WOODMEN HILLS REC CENTER
9205 MERIDIAN RANCH ROAD
EL PASO COUNTY, COLORADO

JOB NUMBER	953-20
REVISIONS	
ORIGINAL DATE	10-1-20
DRAWN BY	JM
DESCRIPTION	LANDSCAPE PLAN
SHEET NO.	L1.1

Landscape Plan drawings v_1.pdf Markup Summary

# ENLARGED BUILDING AREA GRADING PLAN

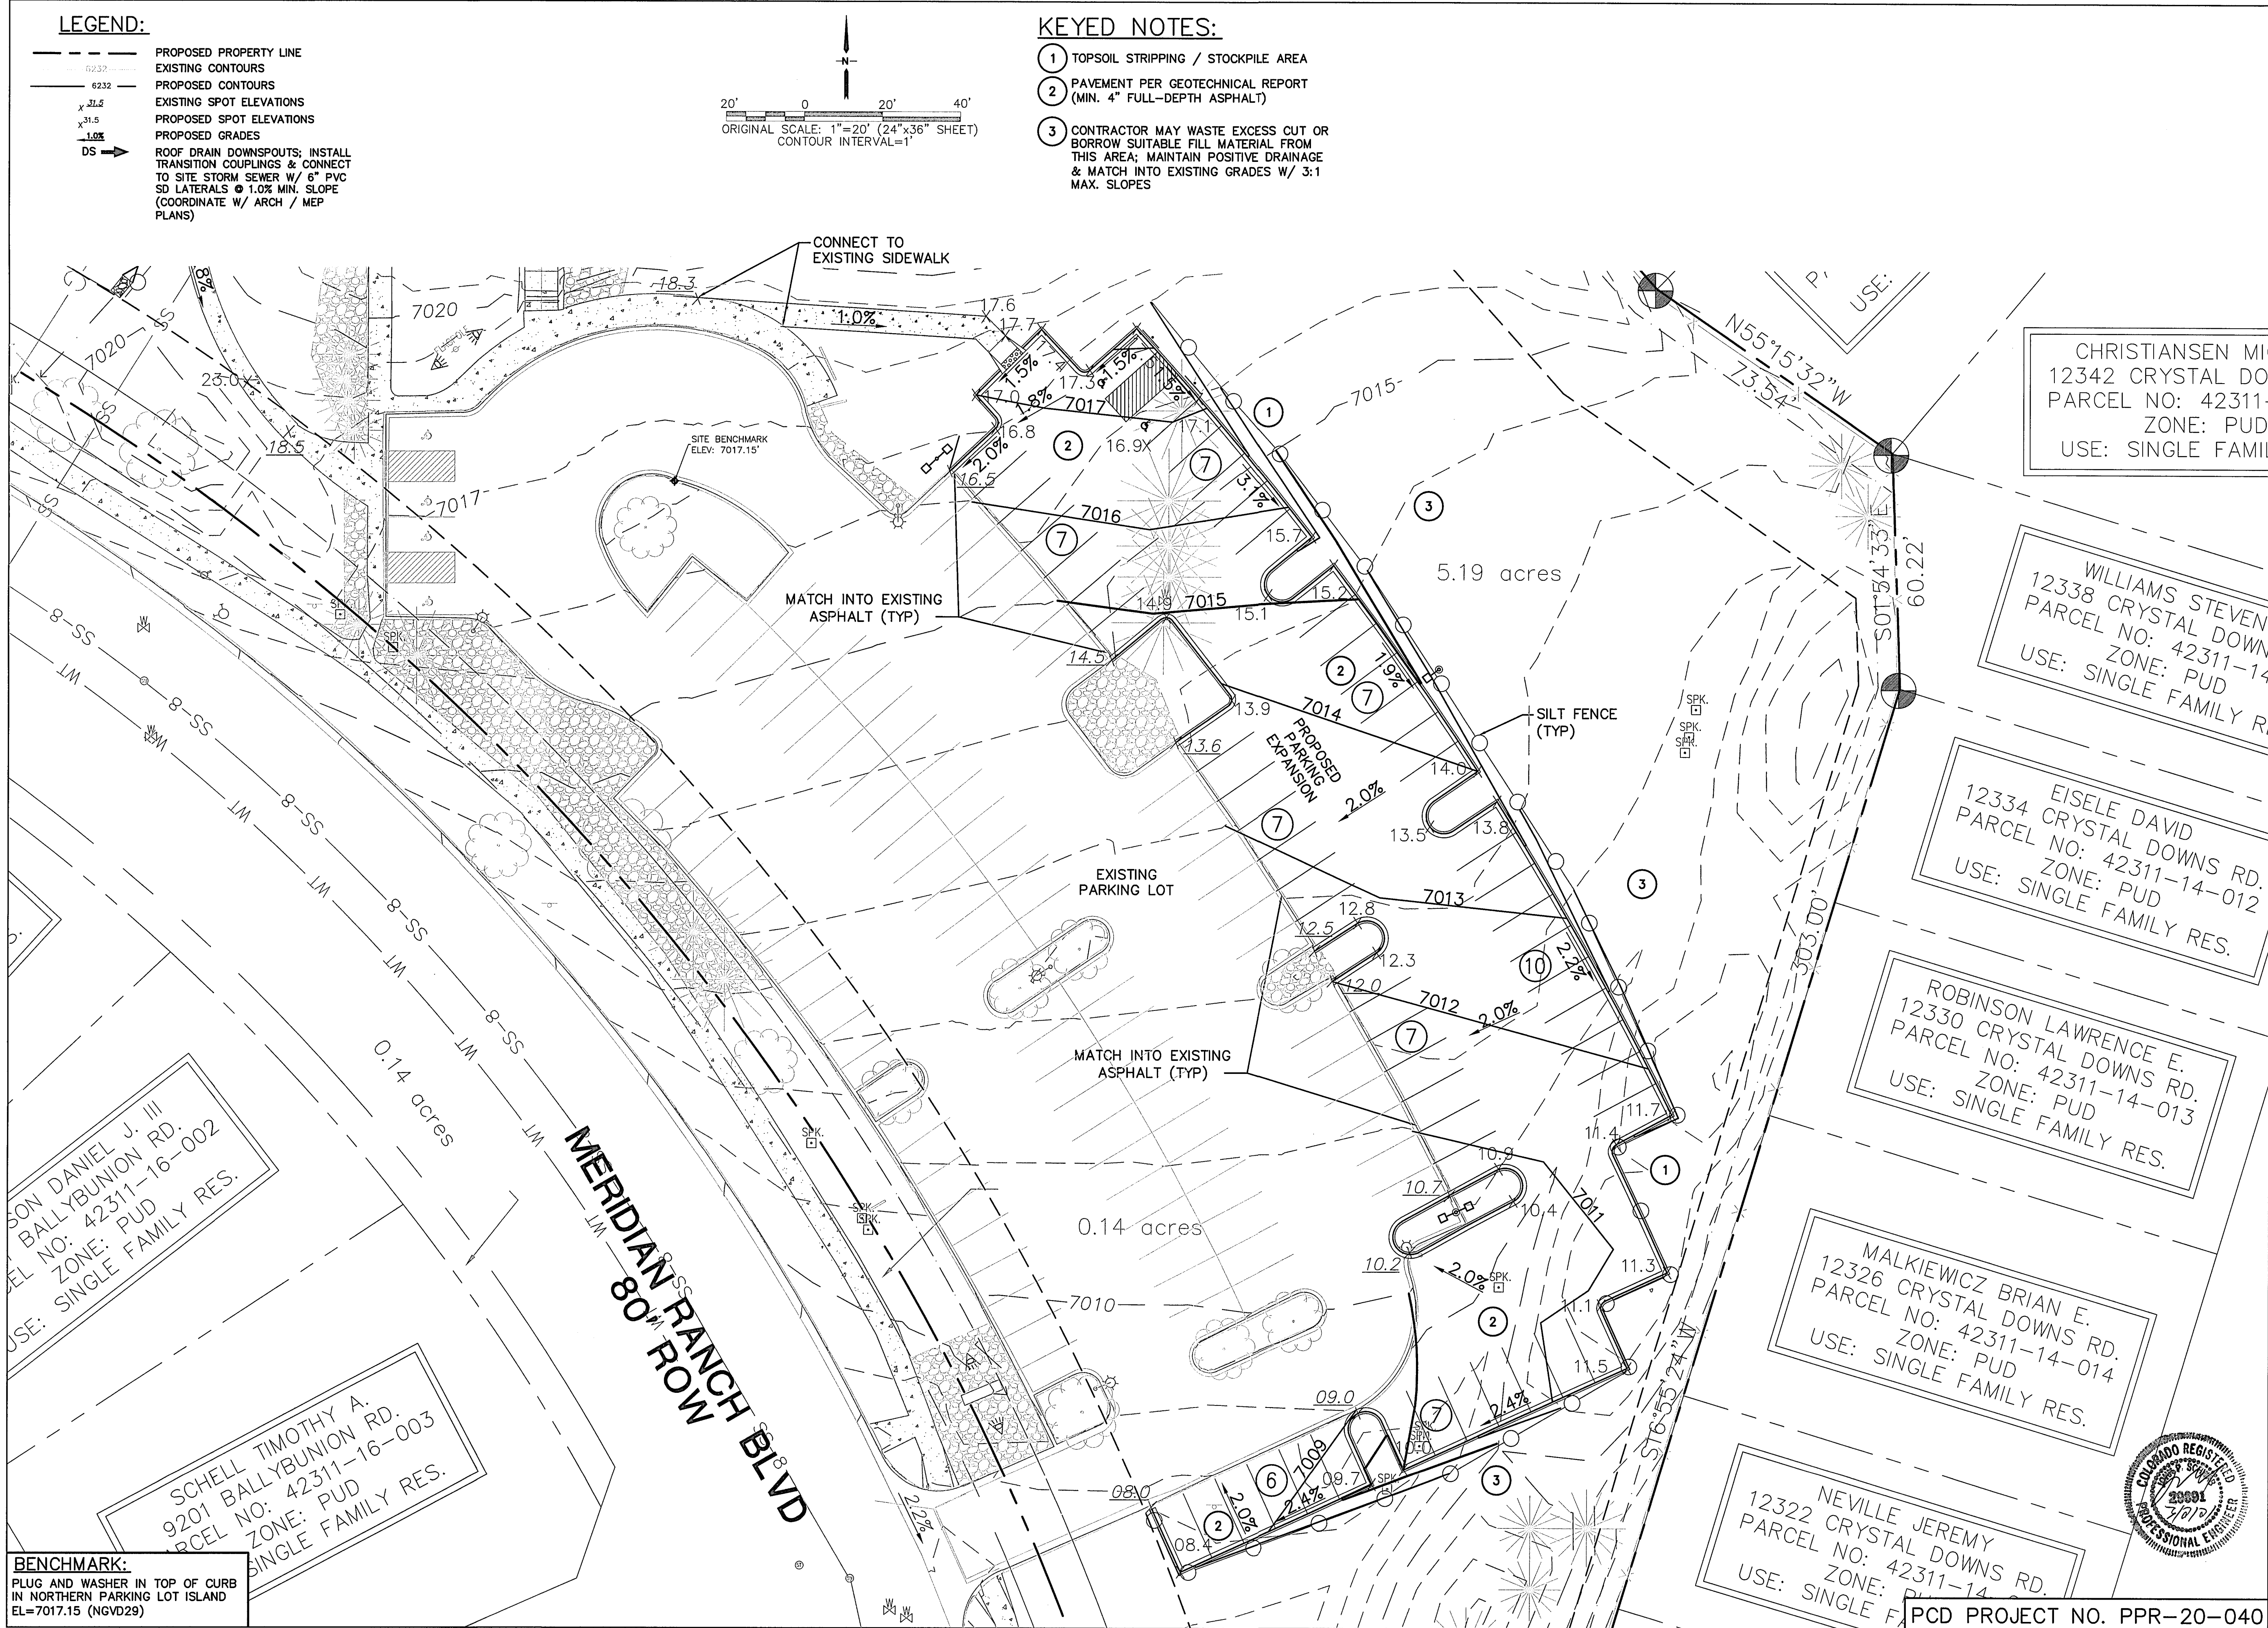
Slope appears to exceed 2% max and may not comply with ADA regulations. Staff recommends adjusting proposed slopes.

LANDSCAPE PLAN AREA-A

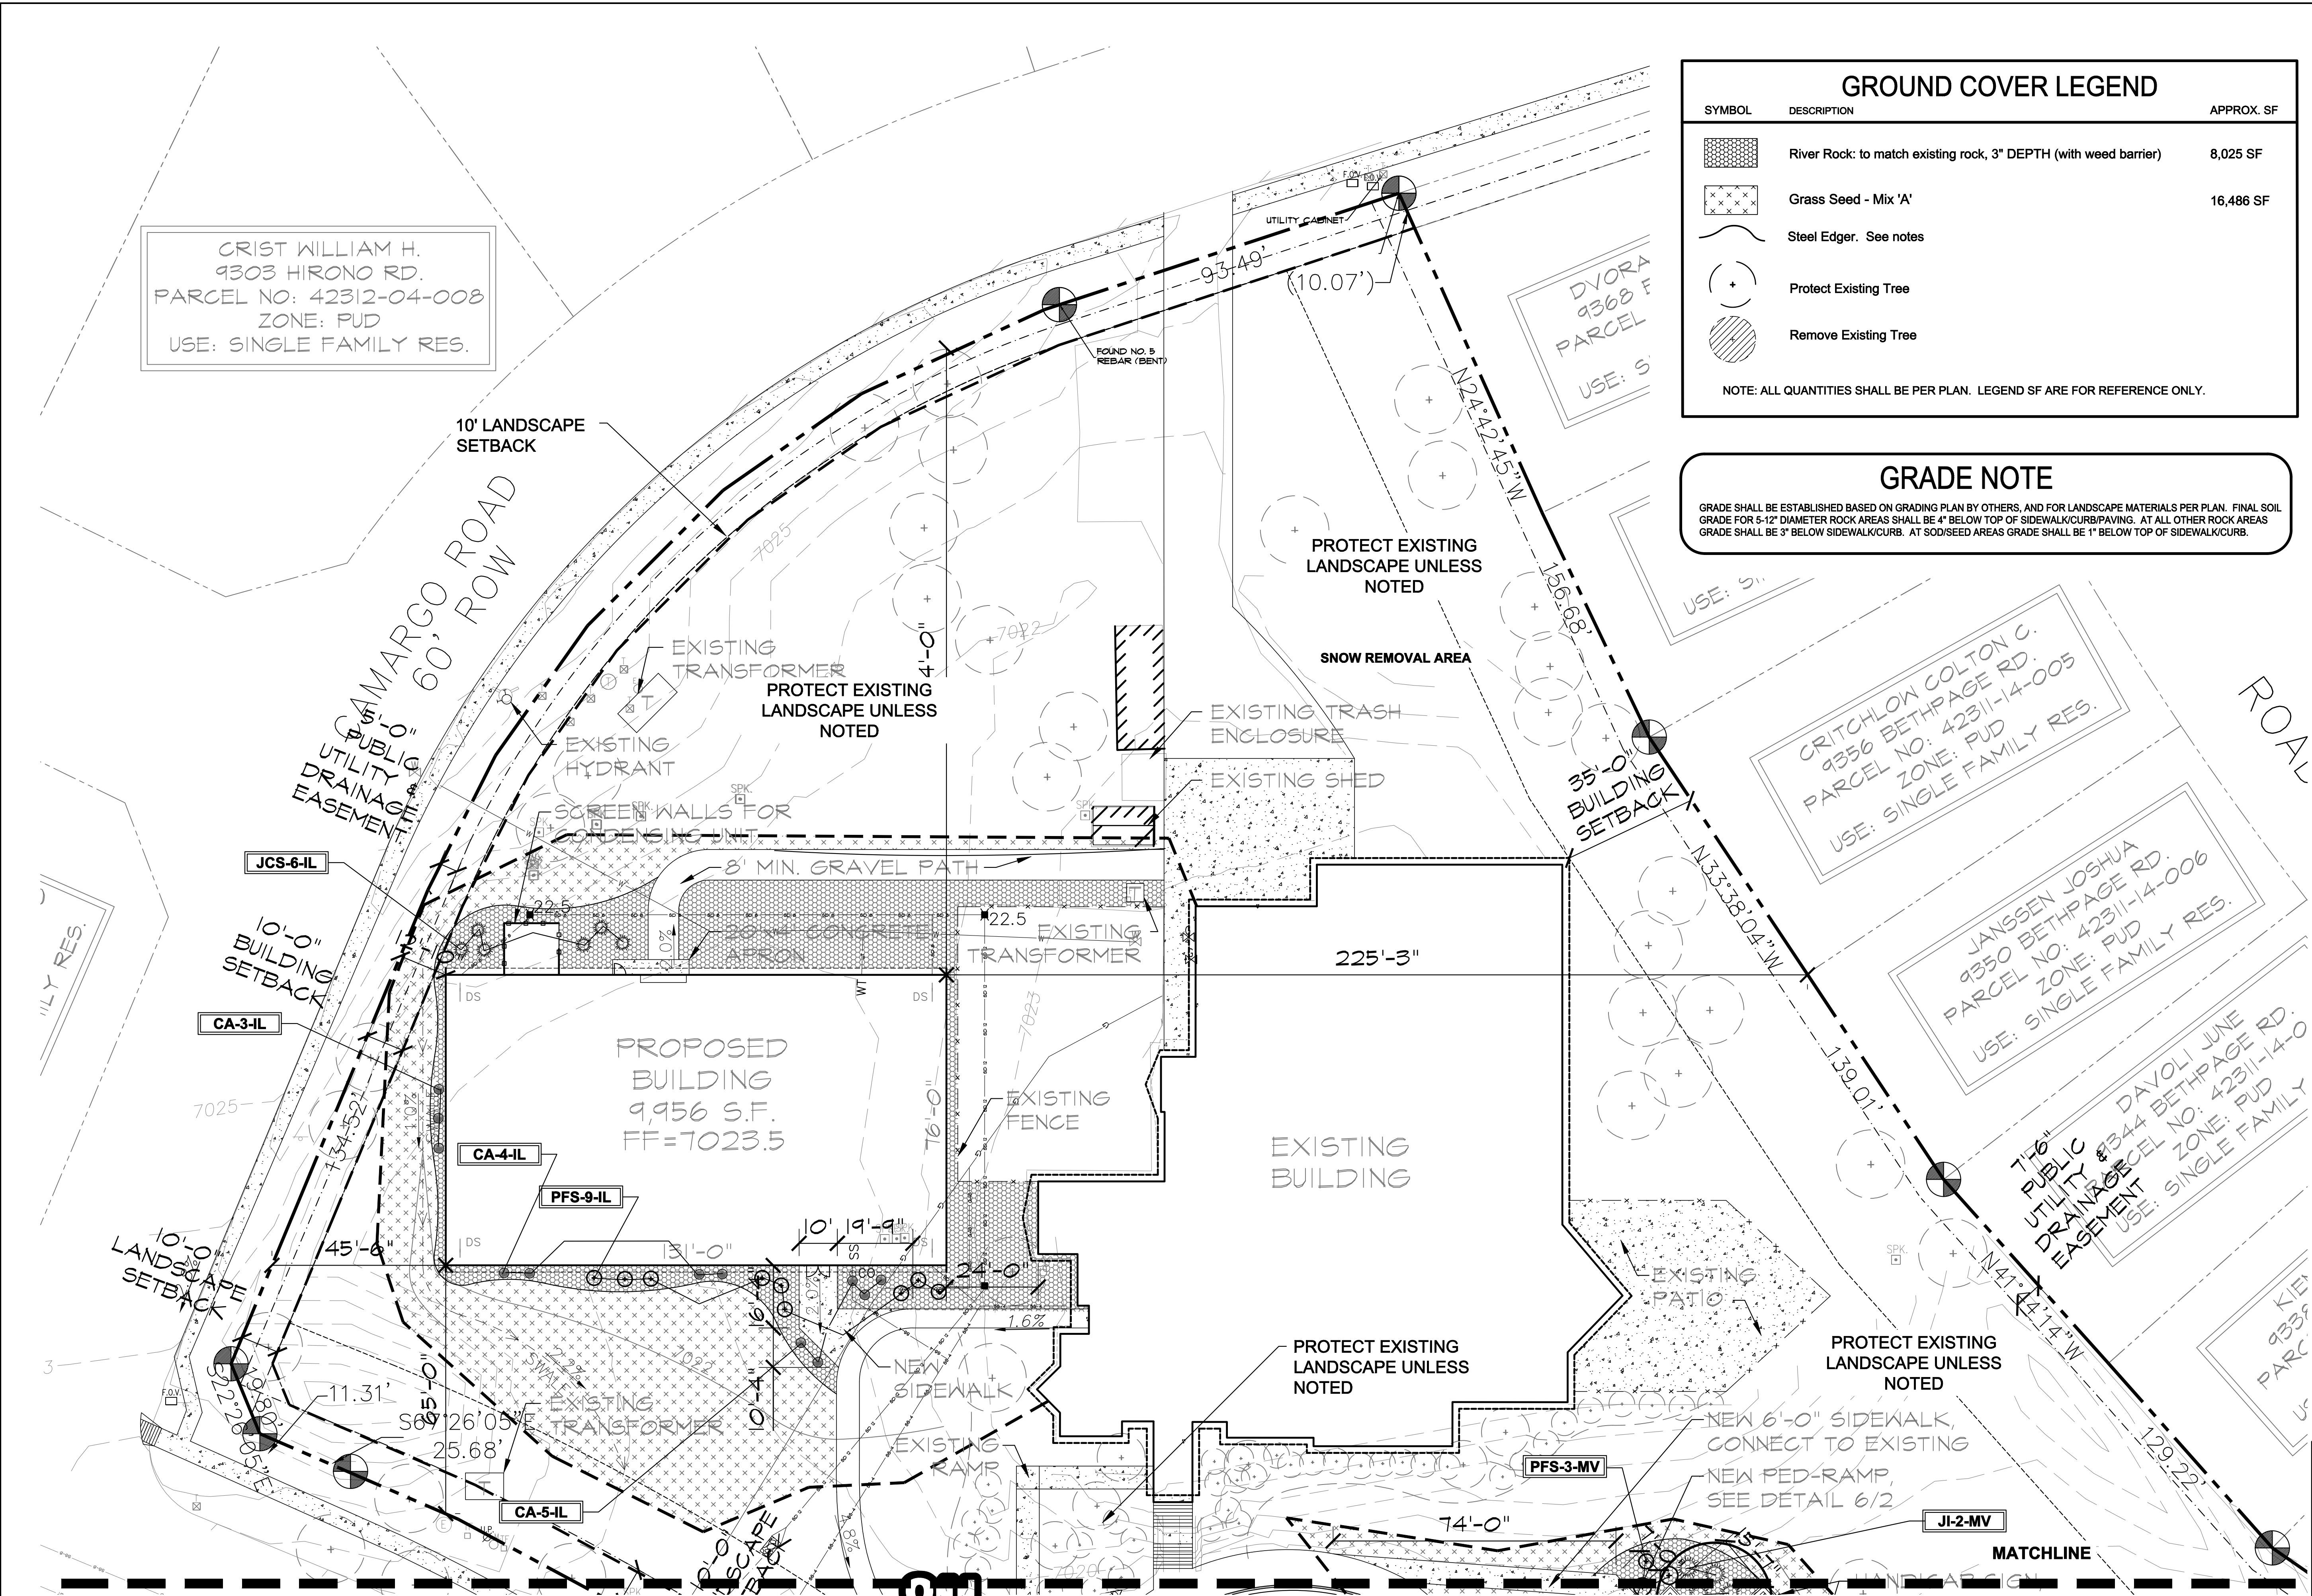
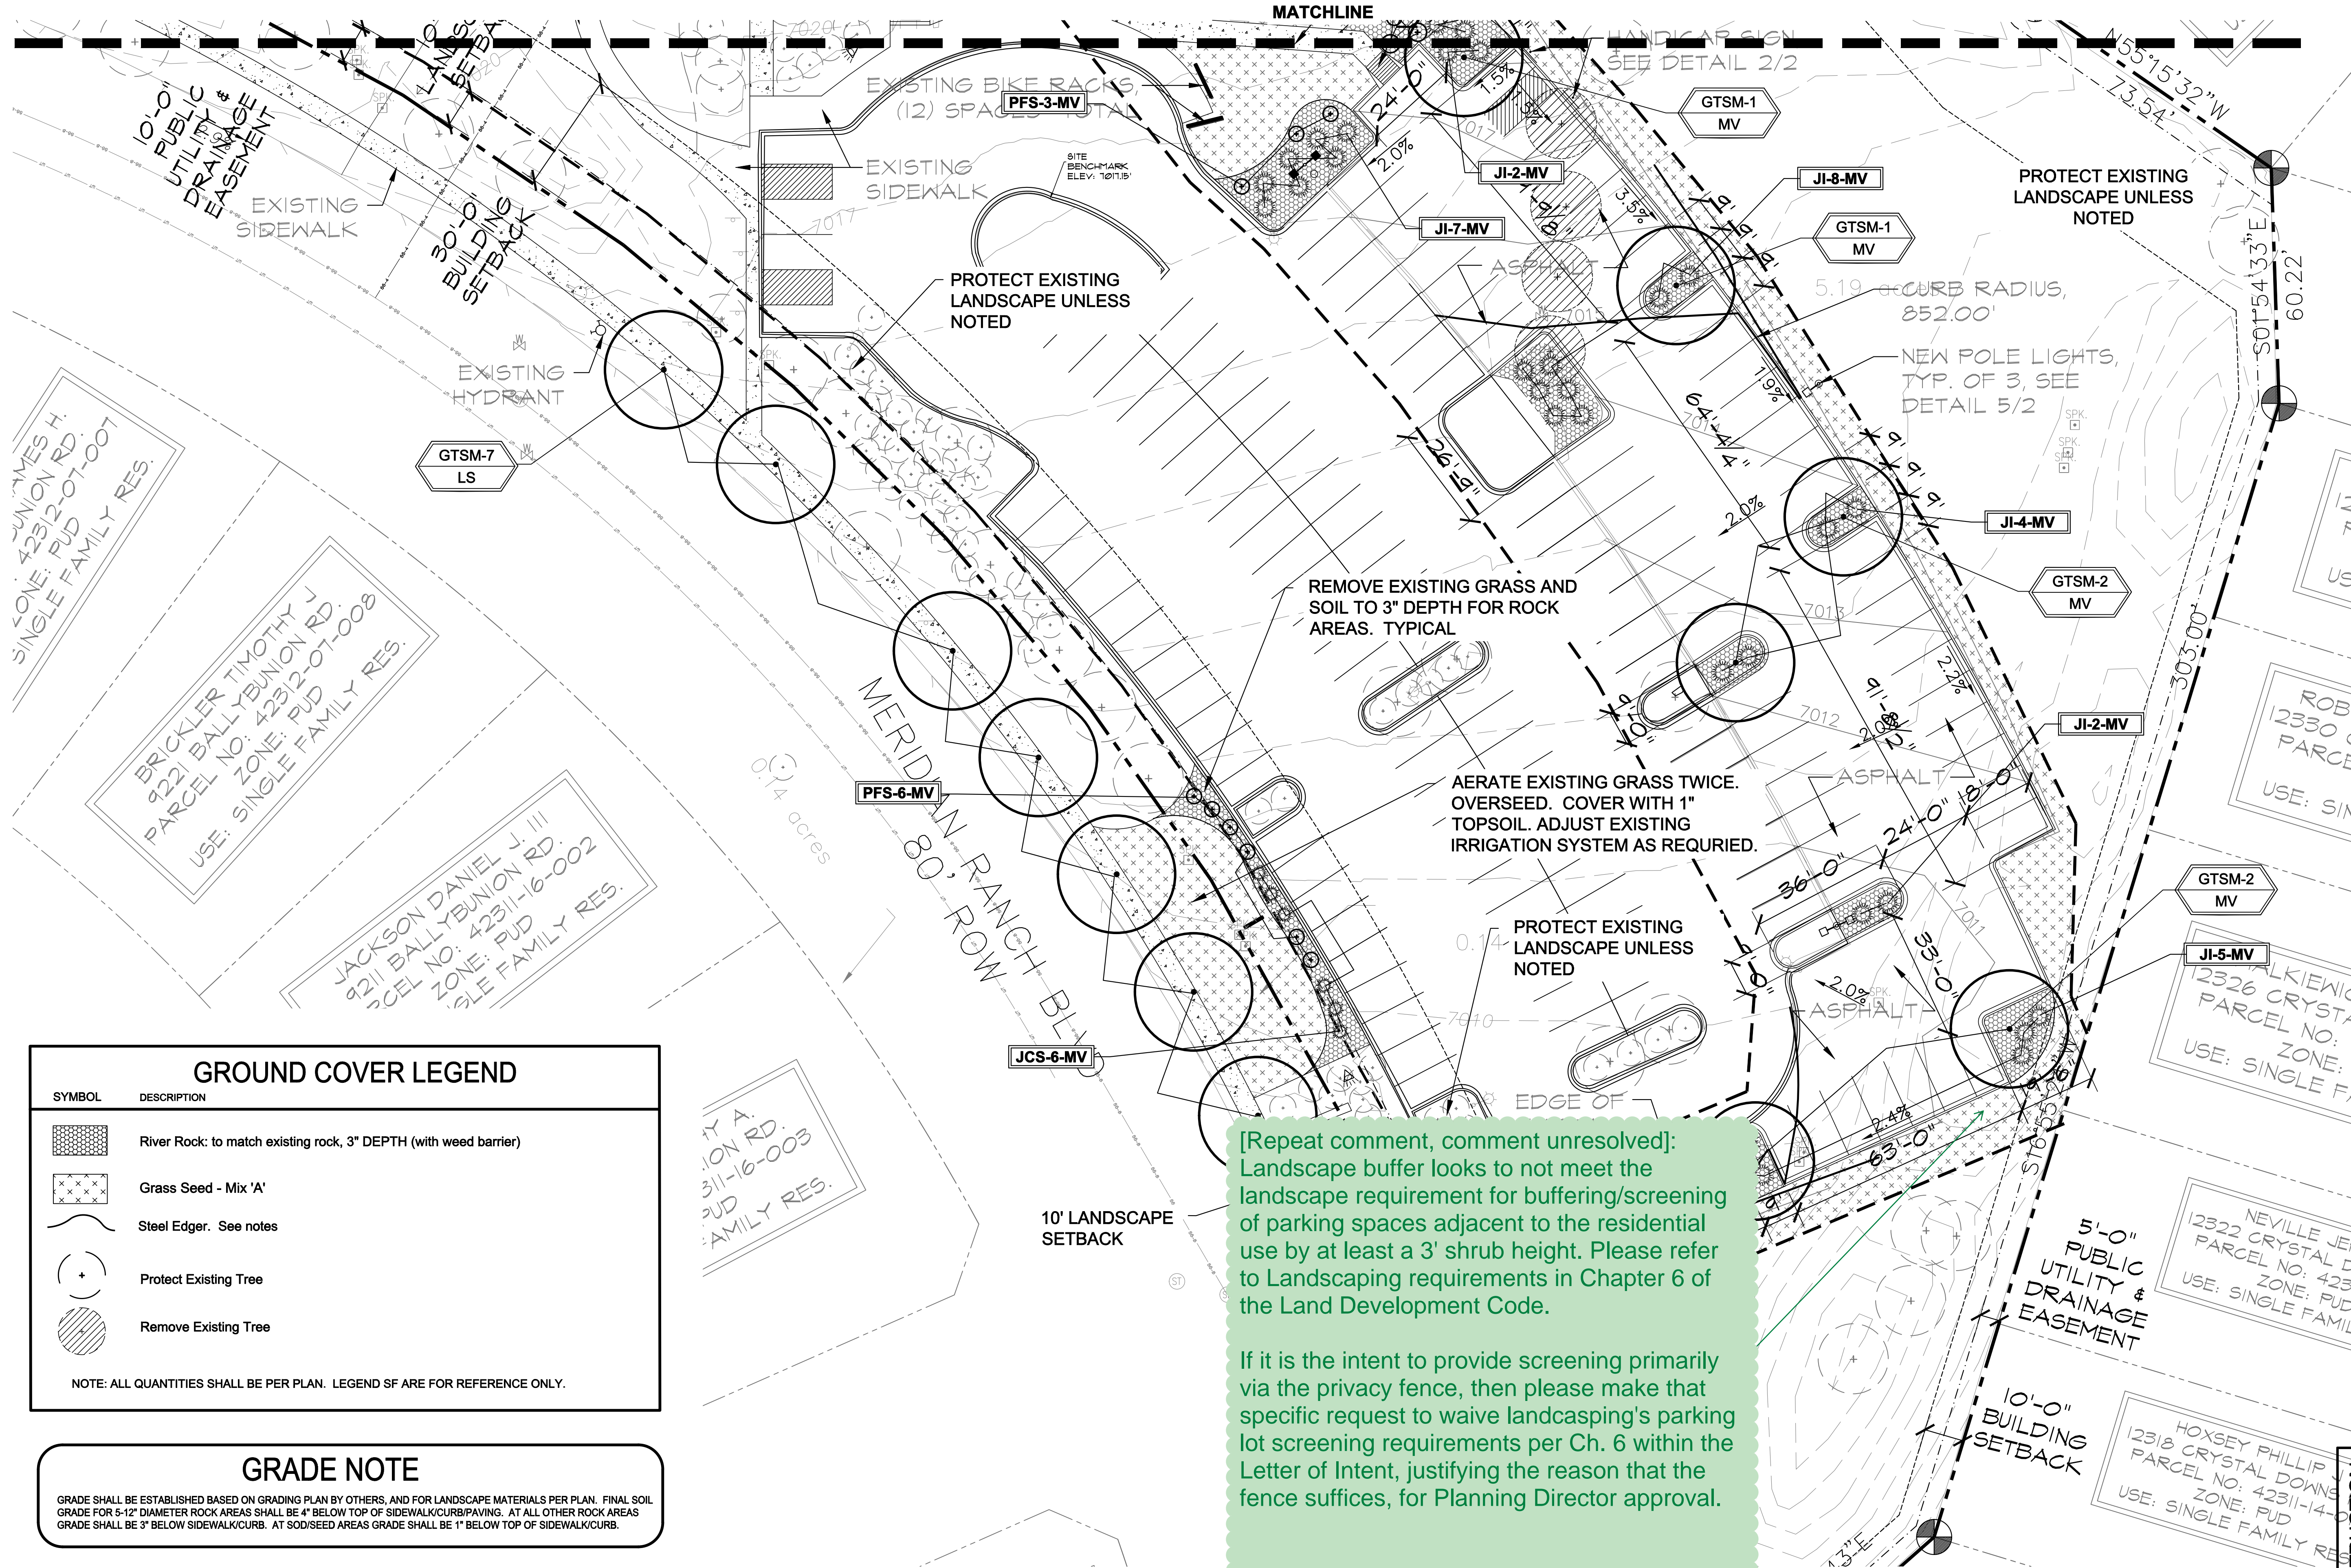
Landscape buffer looks to not meet the landscape requirement for buffering/screening of parking spaces adjacent to the residential use by at least a 3' shrub height. Please refer to Landscaping requirements in Chapter 6 of the Land Development Code.

If it is the intent to provide screening primarily via the privacy fence, then please make that specific request within the Letter of Intent, justifying the reason that the fence suffices, for Planning Director approval.

Landscape buffer looks to not meet the landscape requirement for buffering/screening of parking spaces adjacent to the ROW by at least a 3' shrub height. Please refer to Landscaping requirements in Chapter 6 of the Land Development Code.
